Our ref: SSD-10353-Mod-3

Subject: Request for Additional Information for Section 4.55(1A) Modification Application, Tweed Valley Hospital Stage 2 (SSD-10353-Mod-3)

**Figure 3.2** Modified south elevation of the multi-deck carpark.

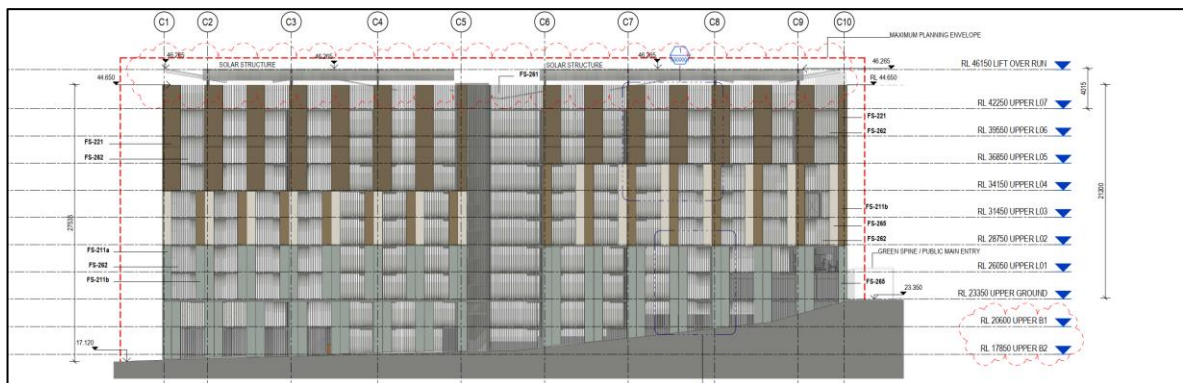
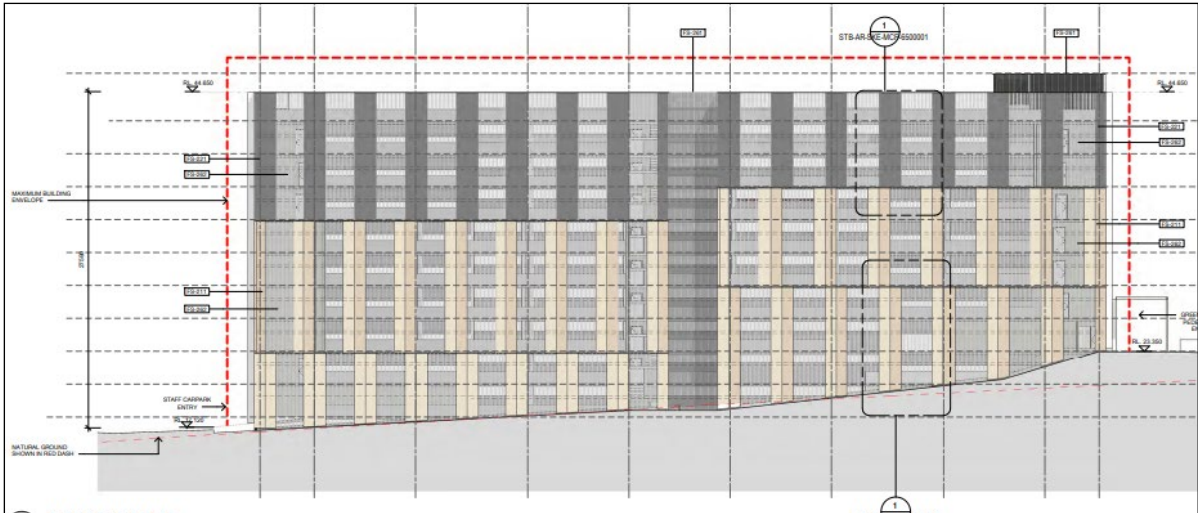
- the architectural report within the original Environmental Impact Statement (EIS) for the Stage 2 application detailed that the multi-deck carpark would have planting that would climb the facades of the structure. As this was considered an important aspect of the carpark's visual presentation in design development, clarification is sought on whether it is still your intent to incorporate the planting into the revised carpark design.
